Our ref: SSD 8699

**Staged Redevelopment of Greenwich Hospital (Concept Proposal) (SSD 8699)  
97 - 115 River Road, Greenwich – Response to Submissions**

## ATTACHMENT 1

DRAWING TITLE:
SENIORS LIVING - SOLAR ACCESS ANALYSIS
DIAGRAM
DATE:
AUGUST 2019
DRAWN:
CM
PROJ:
1213
PROJ ARCH:
BF
DRAWING:
IN.40
SCALE:
As indicated @ A1
REVISION:
P6

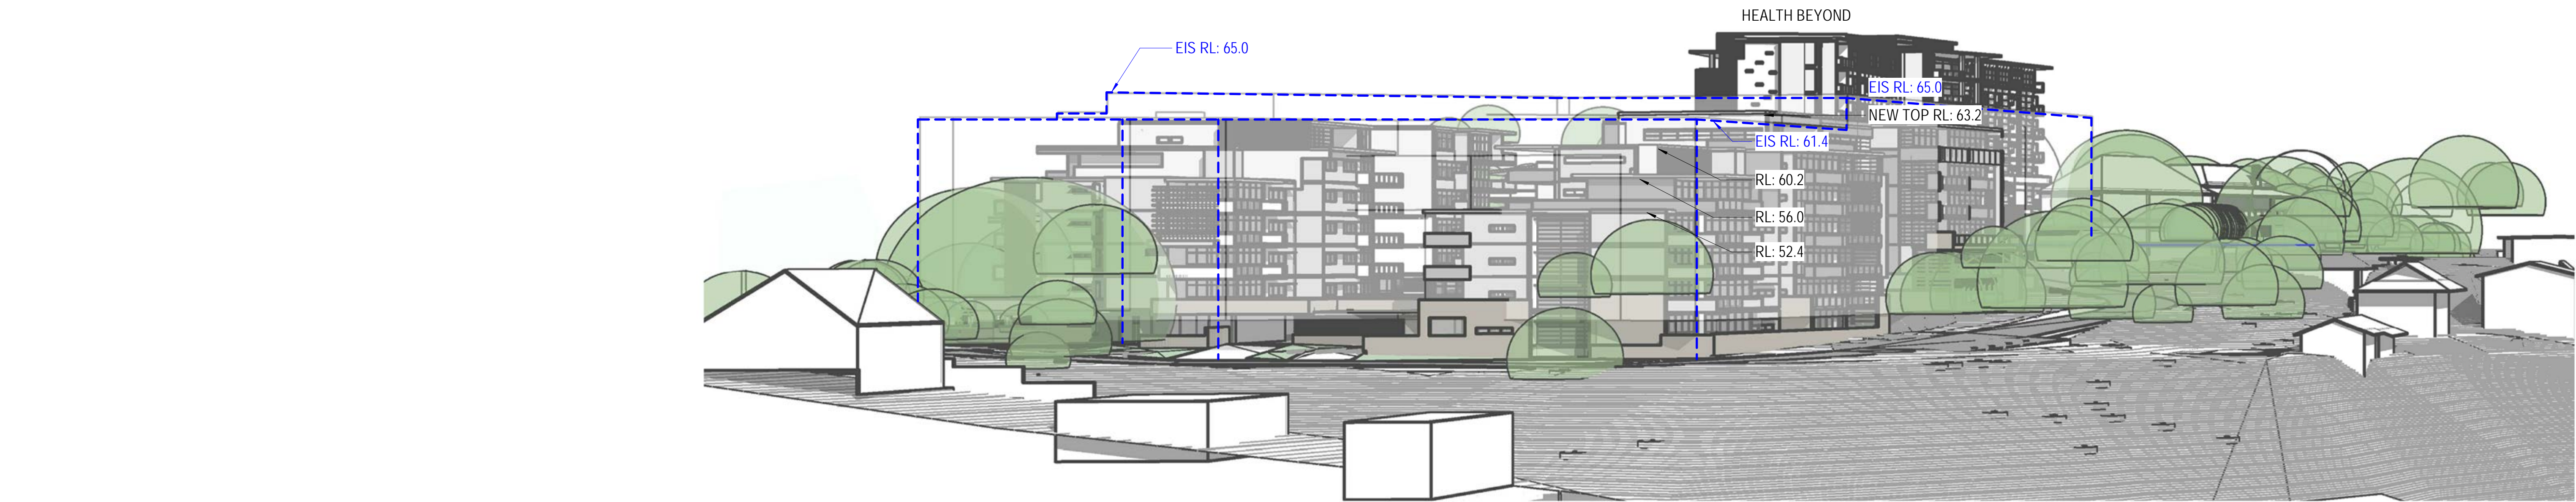
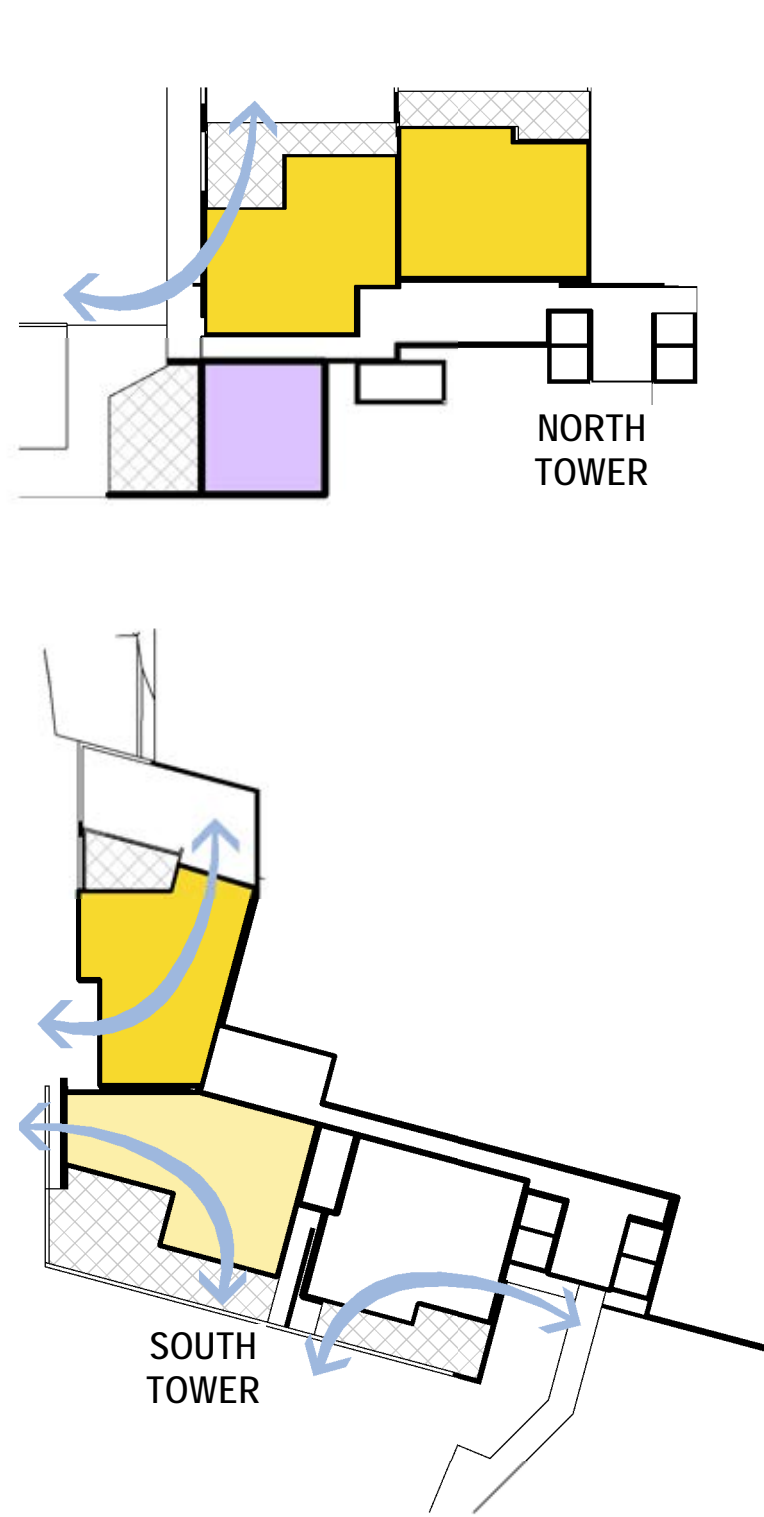
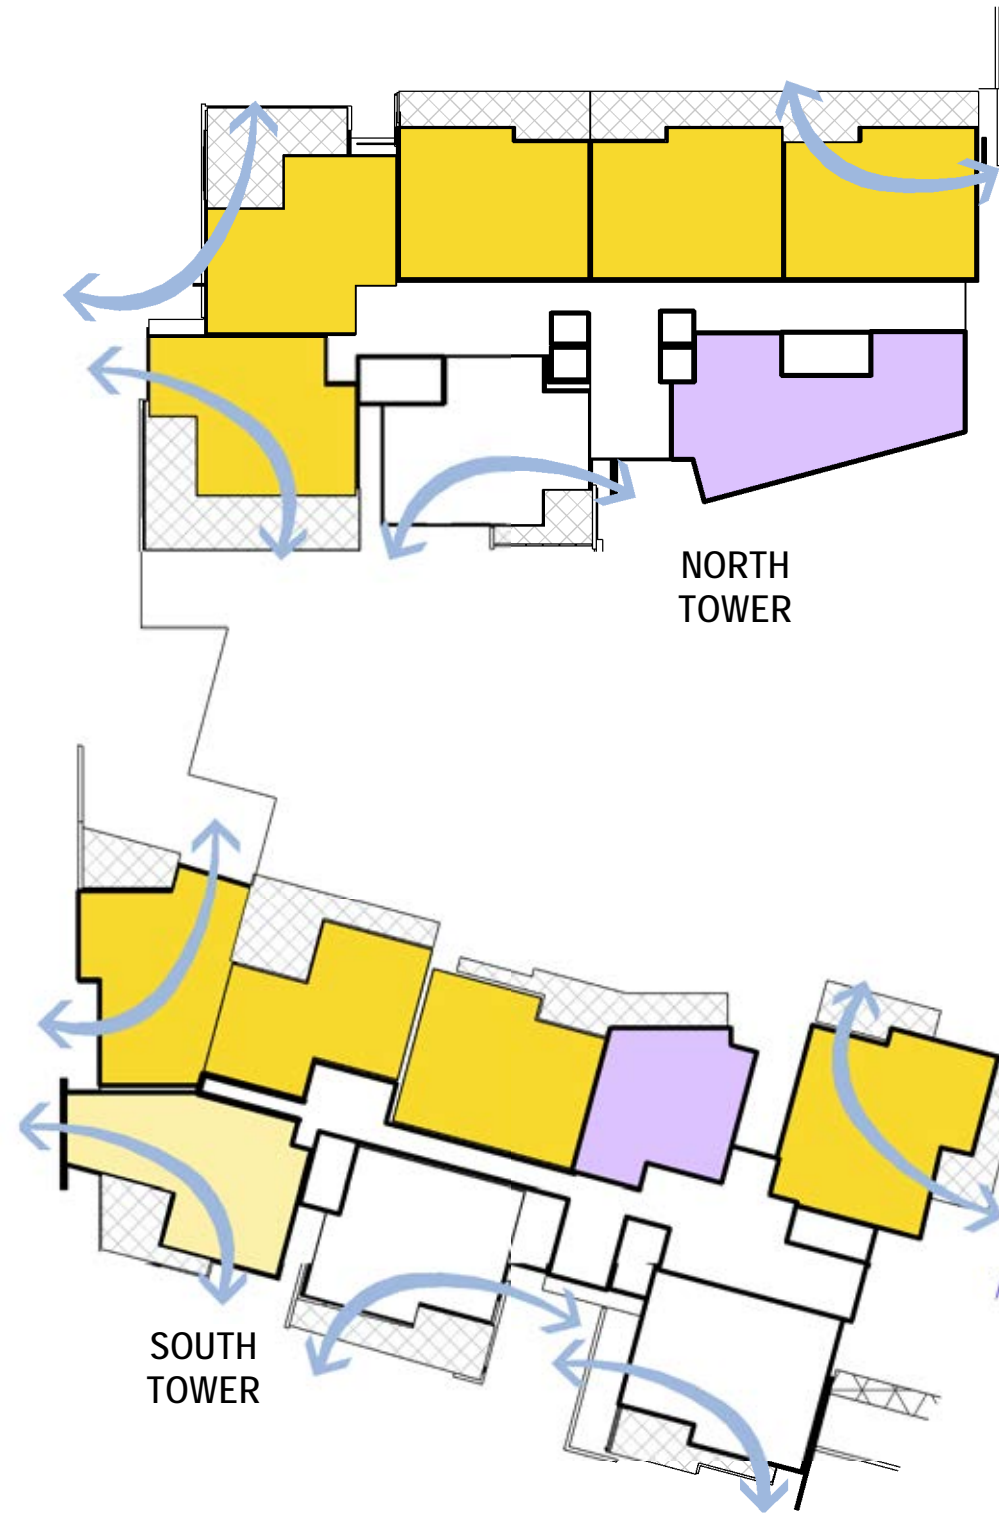
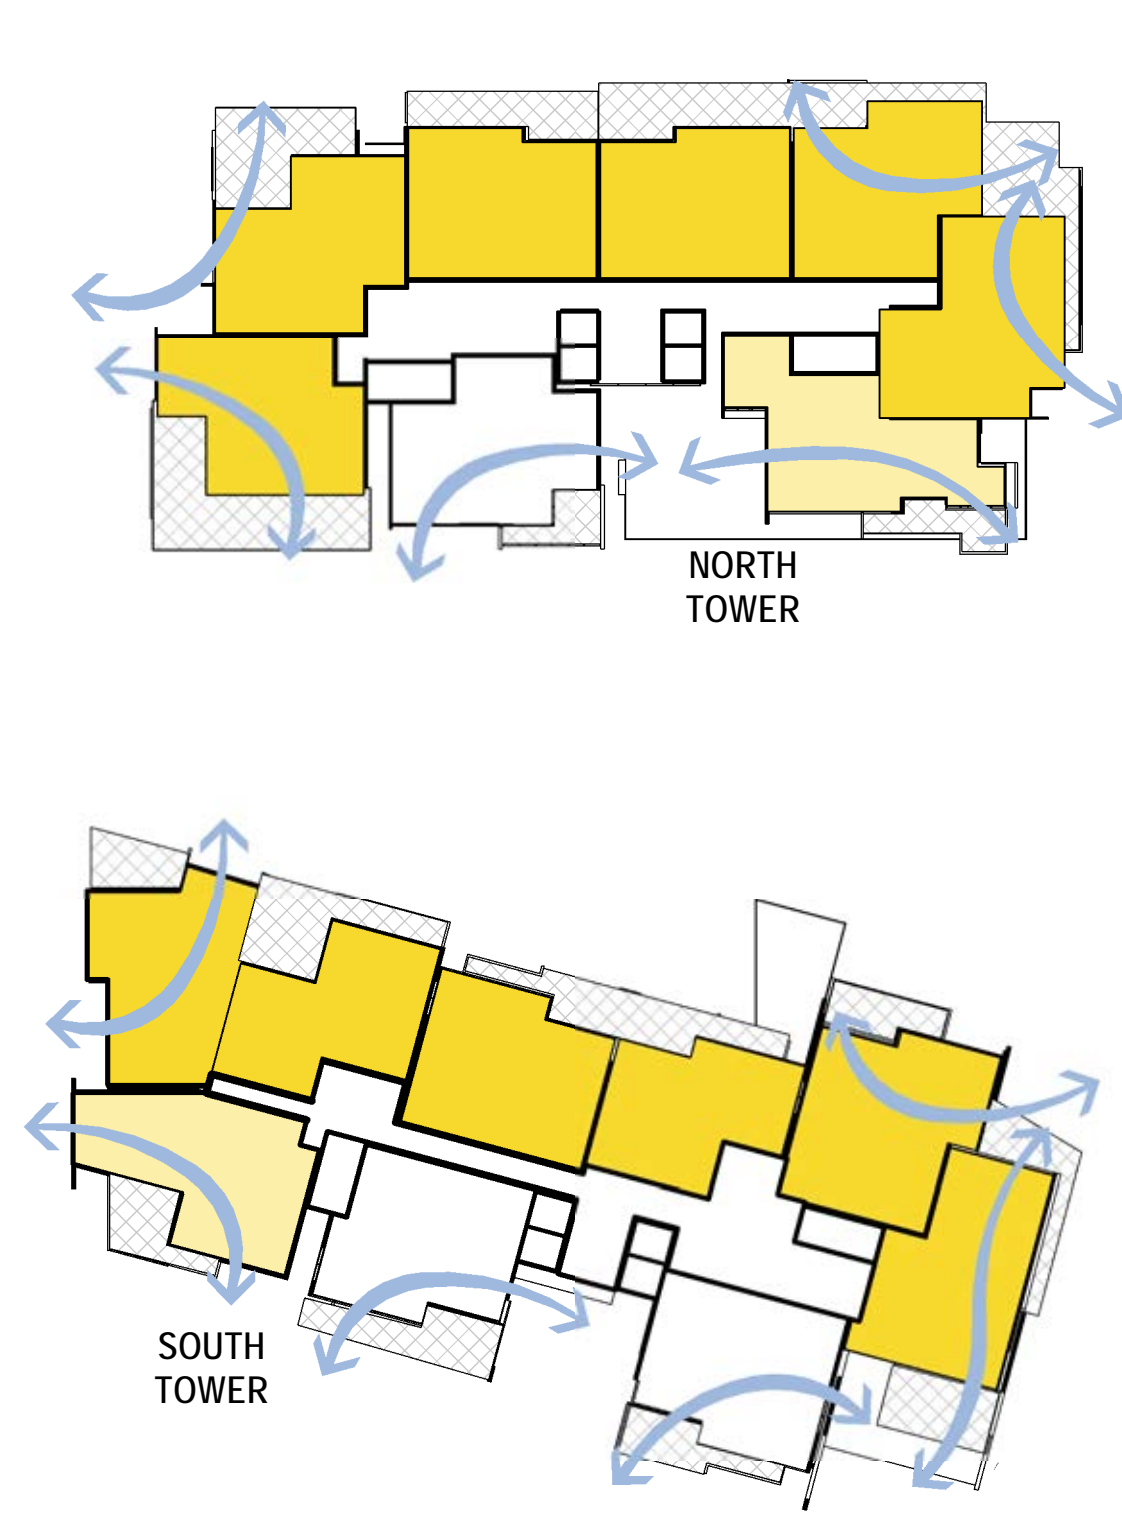
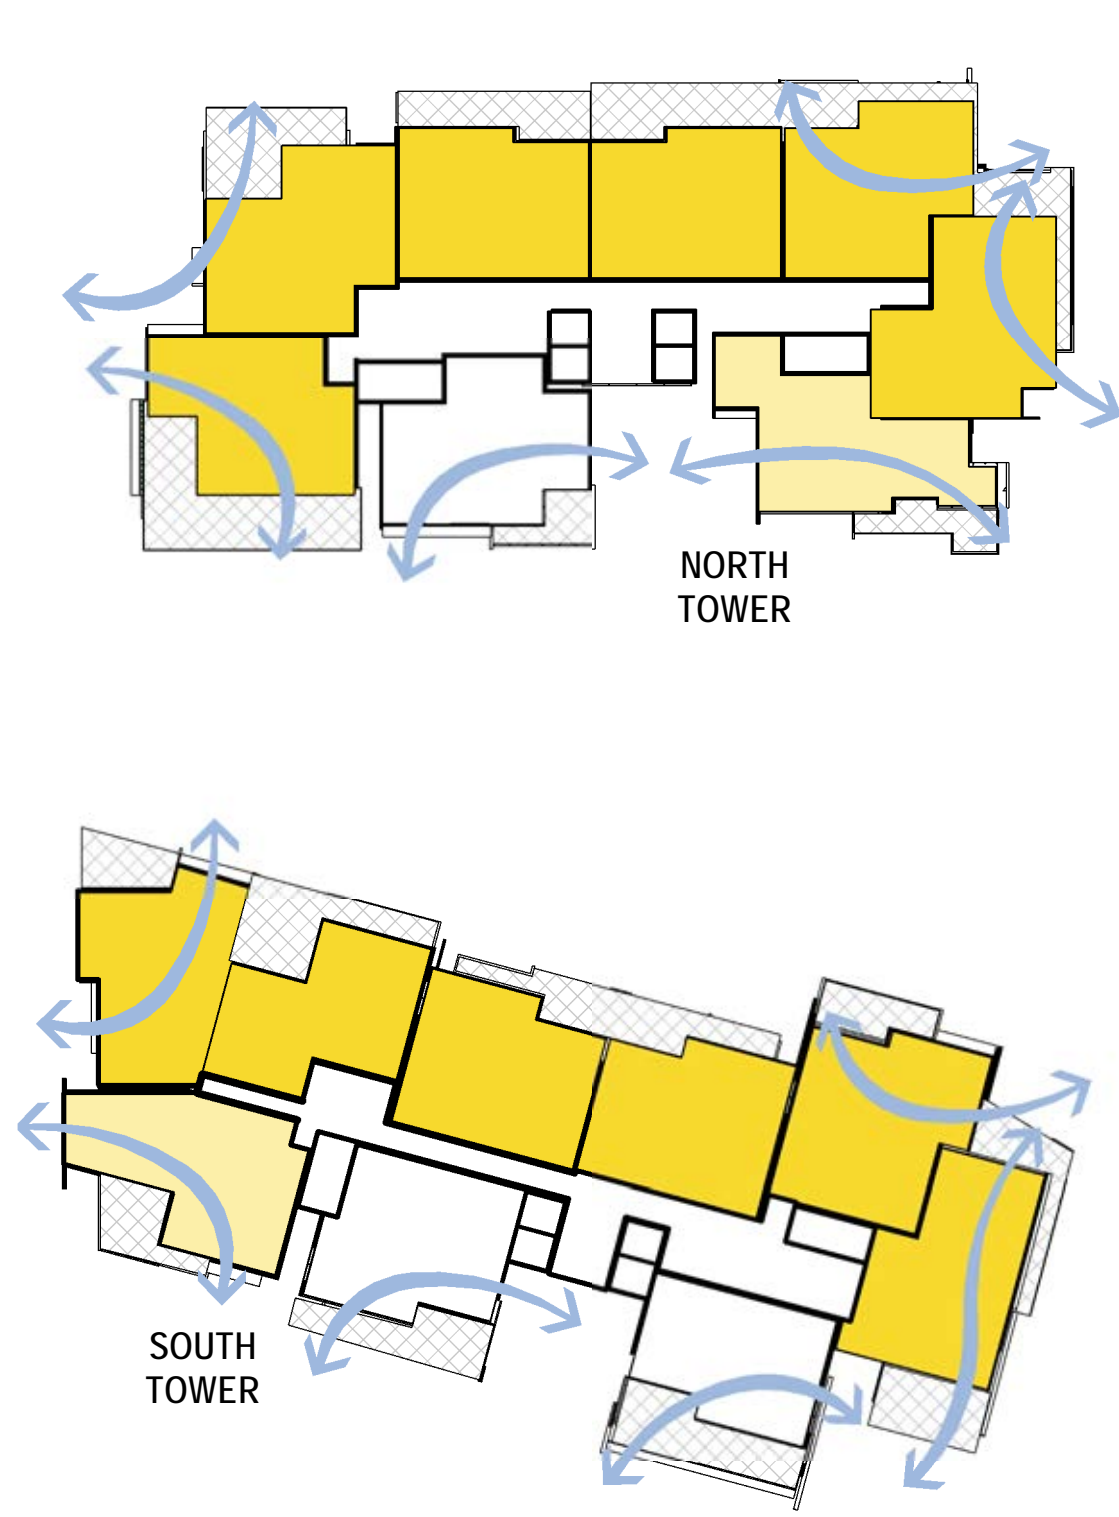
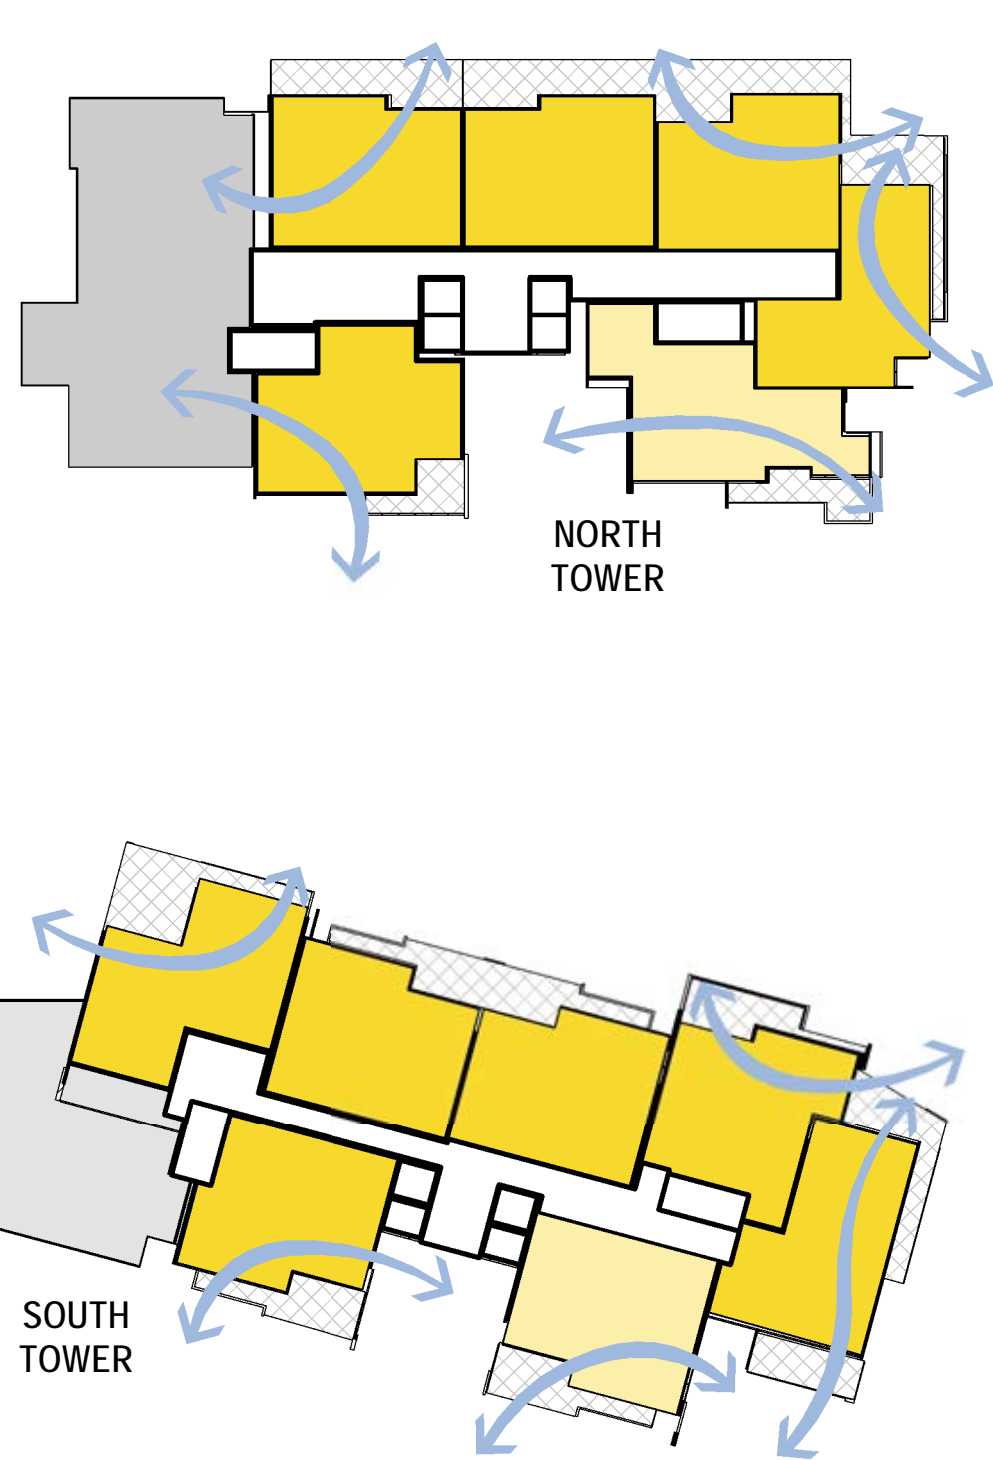
The Department acknowledges the concept nature of the proposal; however it is unclear how 70 per cent of dwellings will receive 3 hours of direct sunlight mid-winter due to the siting and location of the proposed buildings and likelihood of the northern apartment building overshadowing the southern building.

The RtS must demonstrate how solar access would be achieved.
